Our ref: DOC21/127405

**Subject:** West Culburra Concept Plan – NSW Land & Environment Court Revised Application (SSD 3846)

Attachment A – EES Detailed Comments – West Culburra Revised Concept Plan NSWLEC Application

Diagram 11: Stormwater management scheme for the Concept Plan.

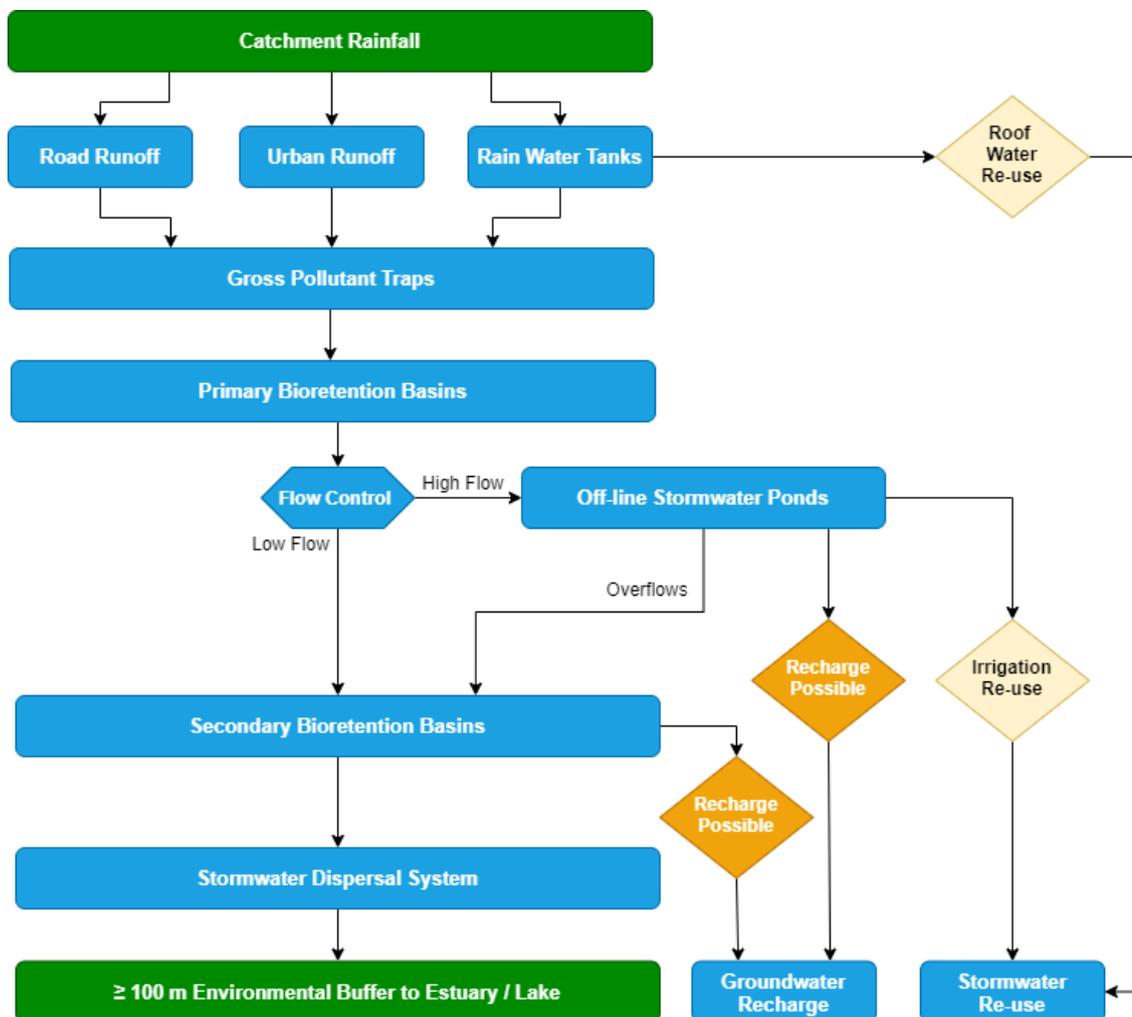
- The Integrated Water Cycle Management Strategy (IWCMS) outlines how the development will achieve Neutral or Beneficial Effect (NorBE) outcomes for both the Crookhaven and Wollumboola estuaries. While the MUSIC modelling files have not been scrutinised, the treatment train proposed to manage both stormwater quality and quantity appear to provide a high level of stormwater treatment and retention that should minimise the impacts to the Crookhaven River and Lake Wollumboola.

- However, given previous MUSIC modelling issues for development proposals in this area and the site’s sensitive location, we recommend that an independent external review of the MUSIC modelling is undertaken. Such a review would determine if all MUSIC input parameters are appropriate, whether there are any errors or biases in parameters and input data sets (eg. calibrating using rainfall data from Nowra RAN Air Station between 1965 and 1973, compared to rainfall from Culburra stations using more recent and longer period of data), and to advise on whether NorBE is realistic for the stormwater treatment train proposed.

- Should the proposal proceed, we therefore recommend that conditions are imposed to ensure the completed stormwater treatment train, inclusive of gross pollutant traps (GPTs), detention ponds, bioretention basins and the stormwater dispersal system, are audited after construction and monitored for performance during the staged development and for a minimum period of 2 years post completion of all stages, before handover to council for ongoing management. In addition, there will need to be a resourcing commitment from council for the ongoing monitoring and maintenance of the stormwater treatment train to ensure performance over the longer term. This monitoring and maintenance should be subject to auditing by the NSW Government a part of any consent conditions.
